PLANNING AMENDMENT

Application No: HIS-0675-11/A1

Description: Proposed extension and alterations

Amendment: Revised floor layout and site layout

Proposed Ground Floor Layout 1:100

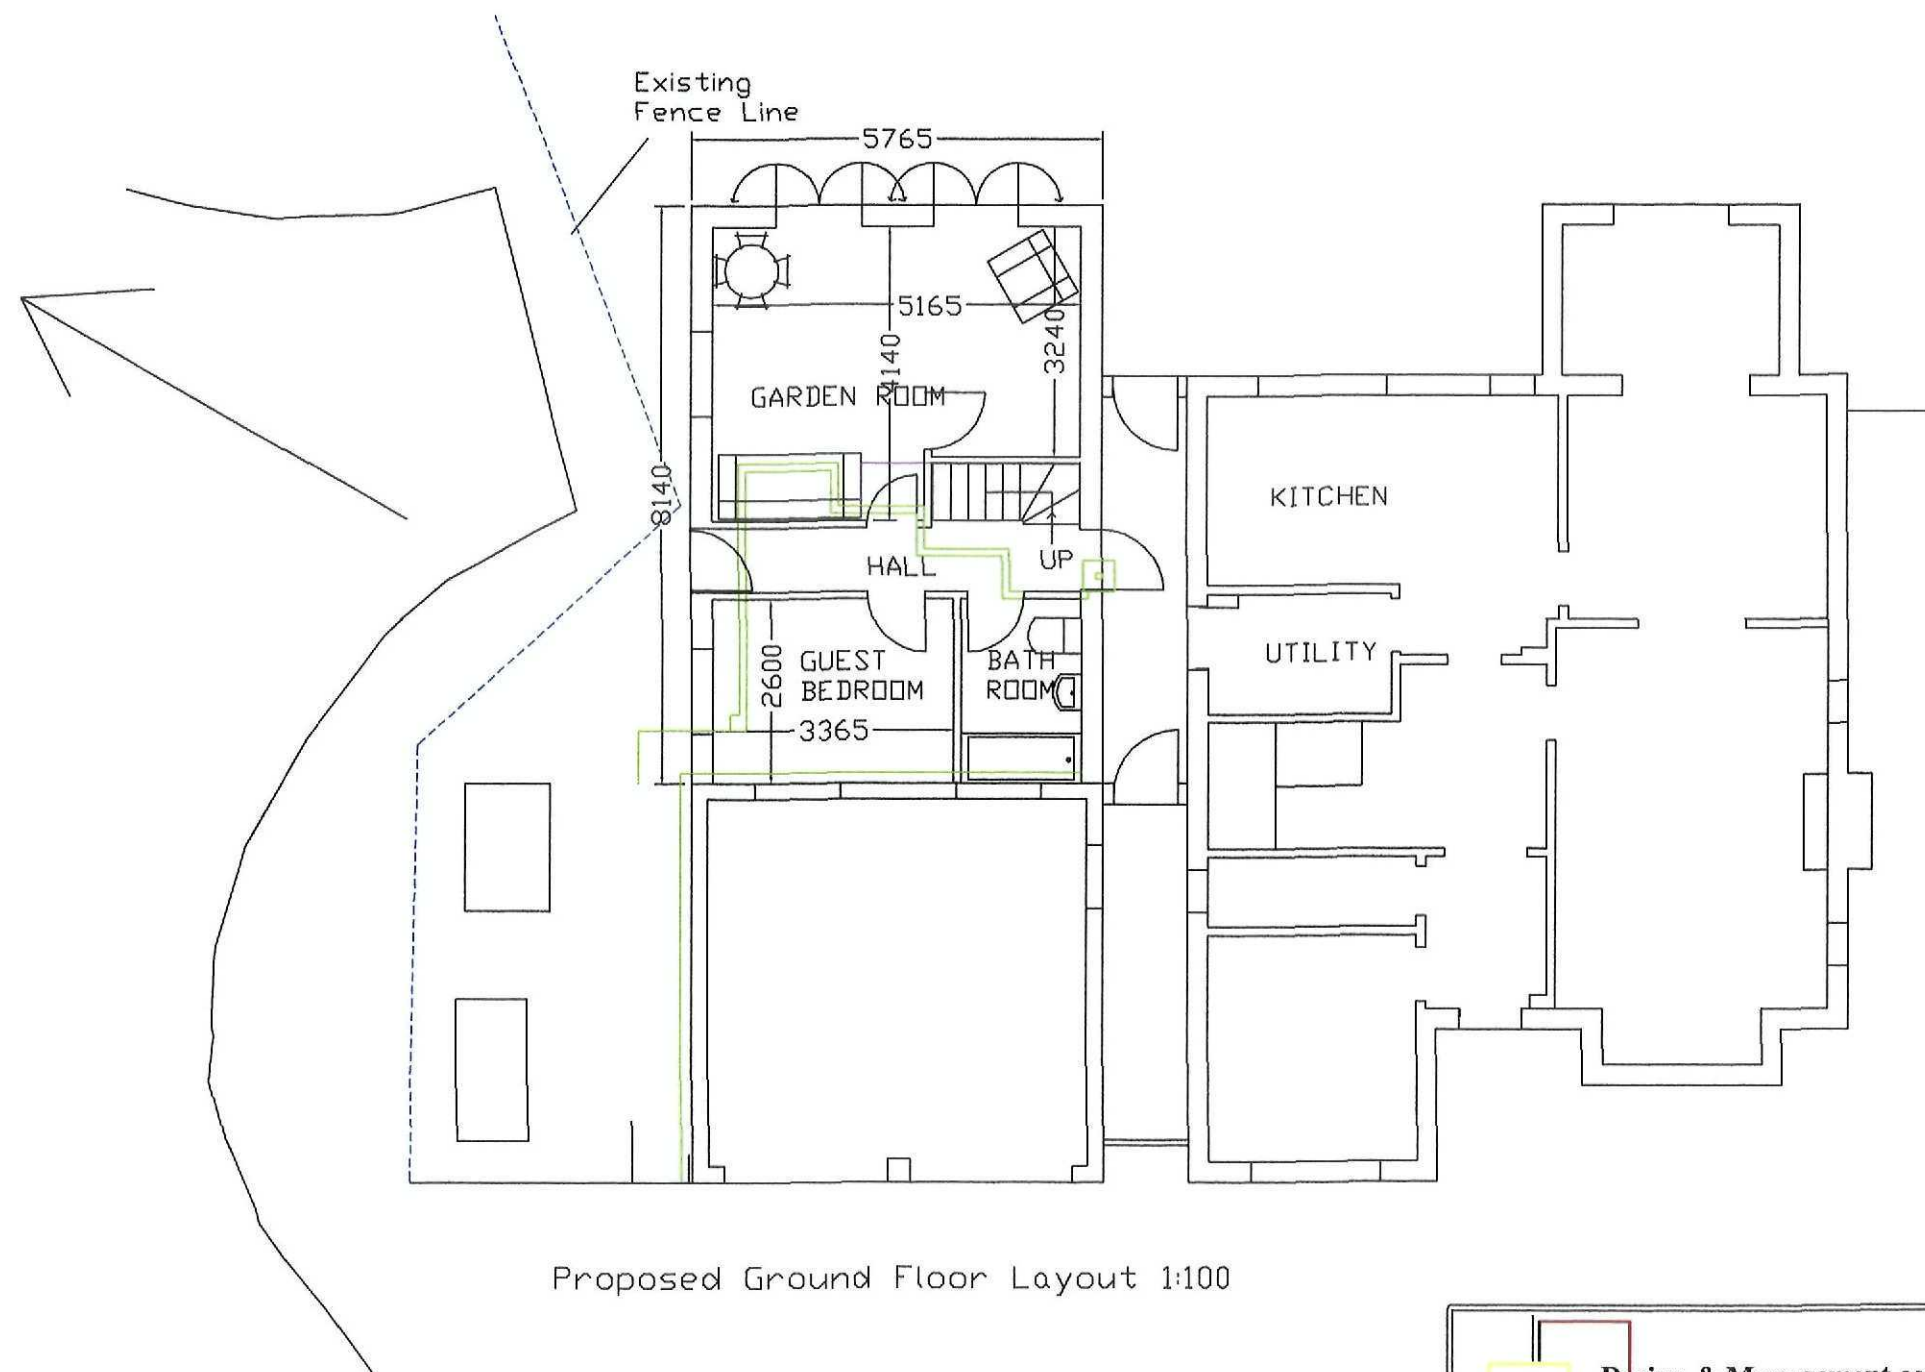
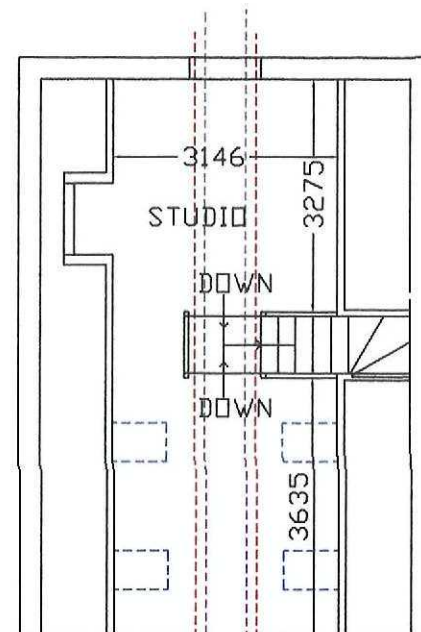
FULL DESCRIPTION OF DEVELOPMENT OF CURRENT APPLICATION THAT THIS AMENDMENT RELATES TO	Extension + alterations	
State details of amendments proposed. (Give a full detailed list of the changes, and also mark these clearly on the accompanying plans. Only the changes listed here will be considered)	Revised floor layout + site layout	
State drawing numbers of the current submission		
Has this amendment been requested by the Council? (If so, state Officer dealing with the application)	YES/NO	
Describe any part of the original development which is excluded by virtue of the amendment, and state any alteration to plot numbers		
Has a similar amendment been submitted under Building Regulations? (If so, state Building Control Surveyor dealing with application)	YES/NO

As you will see it is not necessary to move the fence/s to develop as proposed. I have
however included a small length of fence realignment which is not crucial, but is
desirable.

REVISED (Site Boundary) SITE LAYOUTS 1:500

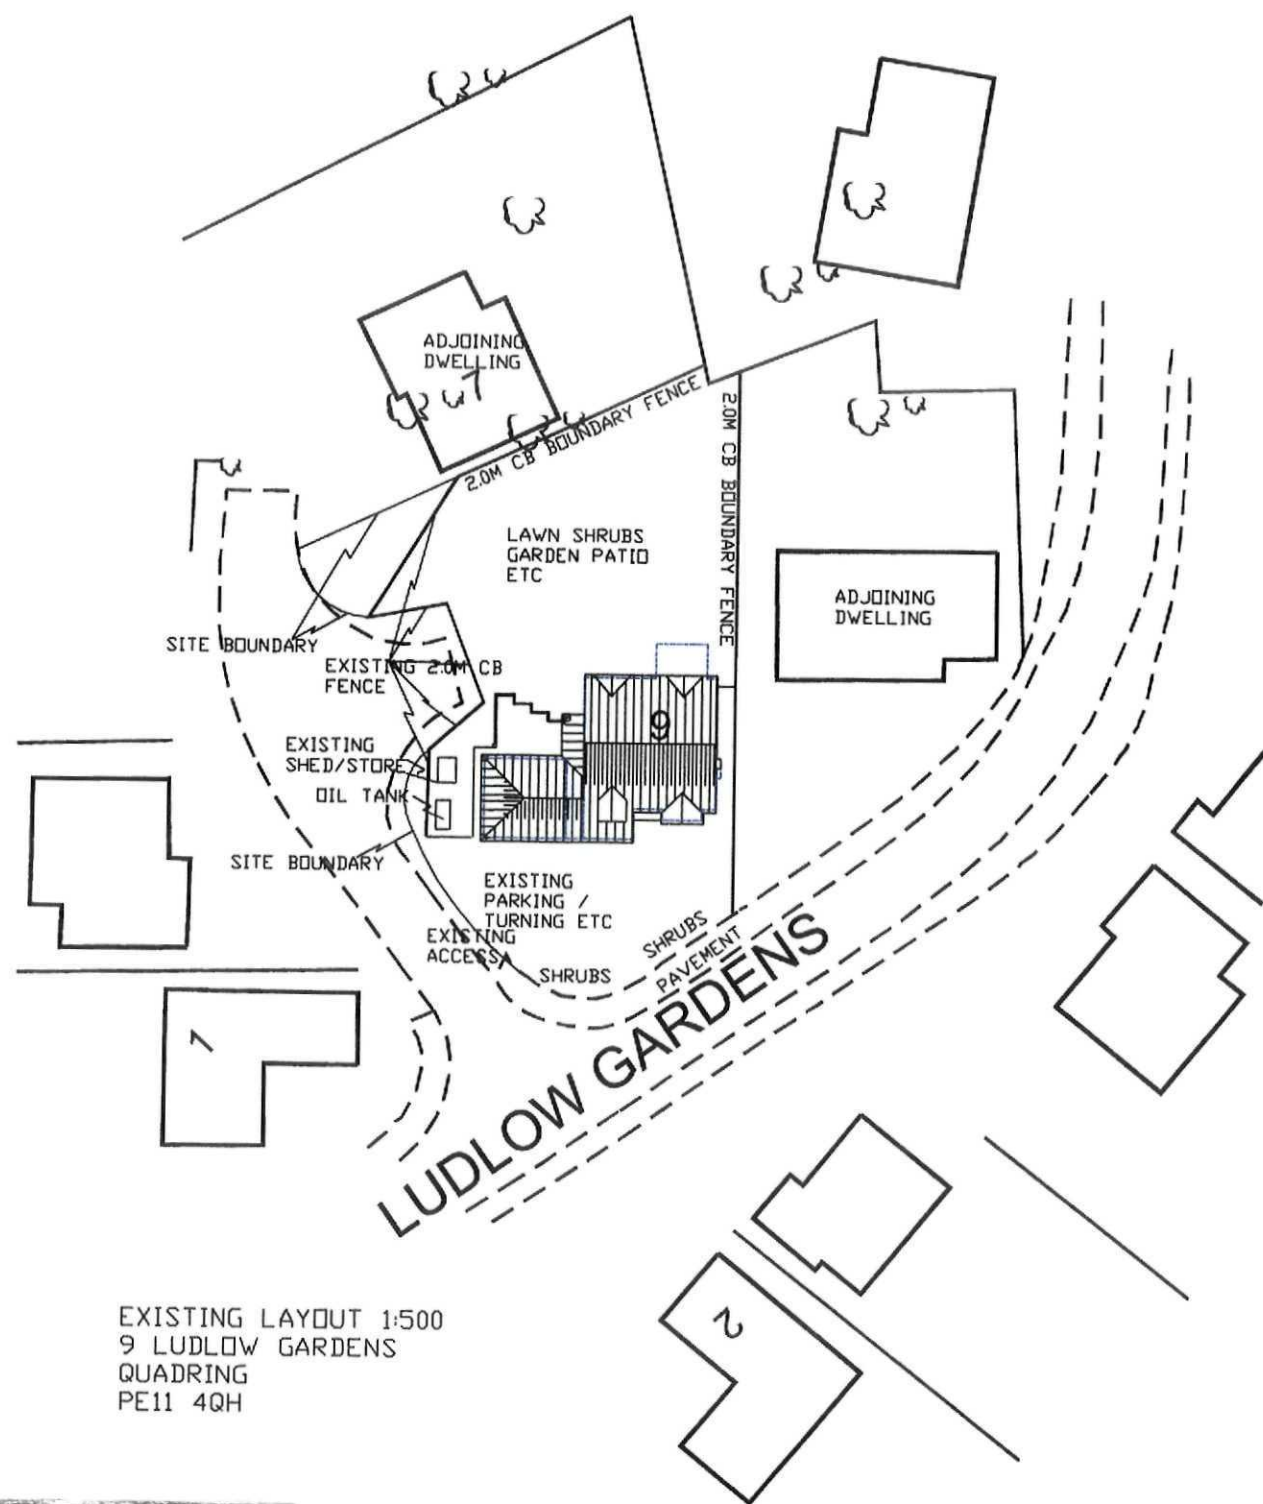
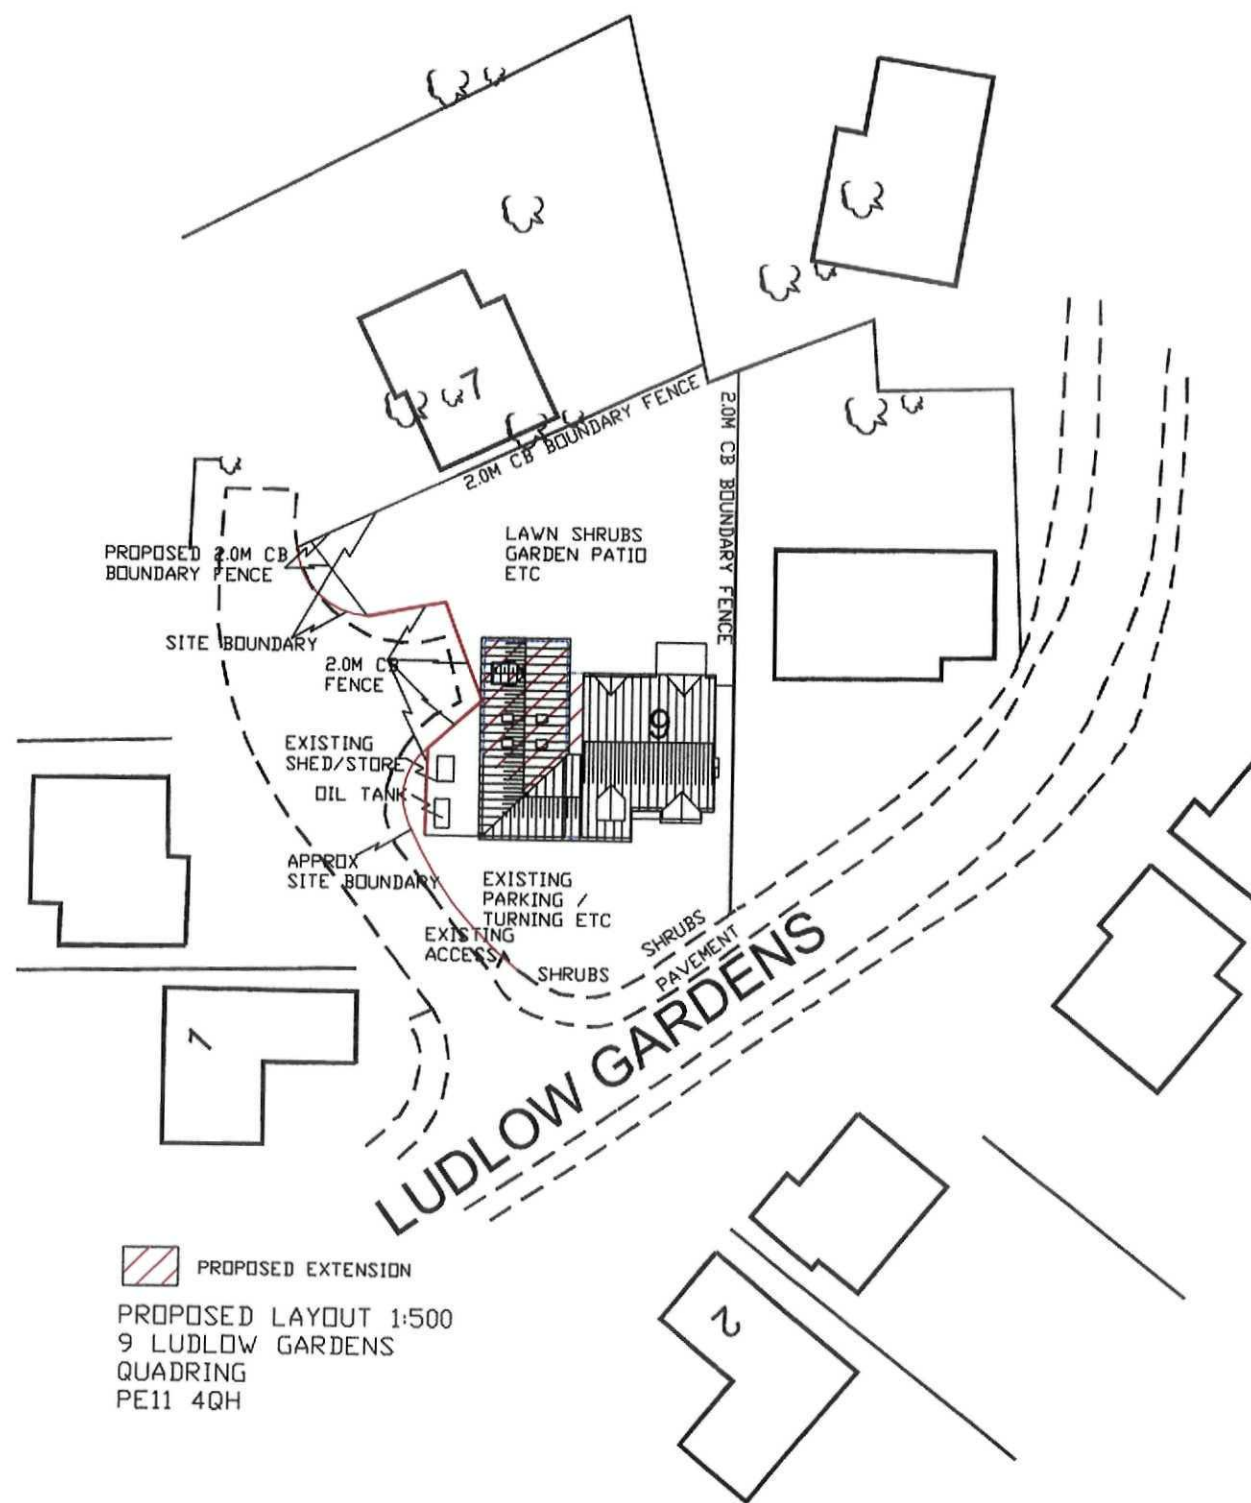
Please find attached ref the above application, revised floor layout at 1:100, revised
site layouts at 1:500 and an additional plan, the Land Registry Title Plan at 1:1250.

I cannot say that LCC Highways agree that my clients boundaries are as shown by the
Land Registry Title Plan, or, as I have revised the other plans to accord with the
Land Registry Plan, those plans.

However in that my clients title dates from 1991 and Highways Adoption and presumably
Title dates from 1994, clearly what had already been transferred by the developer to
my client in 1991 could not subsequently be transferred by the developer to Highways
in 1994. Thus my clients Land Registry Title Plan should be relied on to determine the
site boundaries.

No comments or objections received, and fee line moved back from road is only amendment
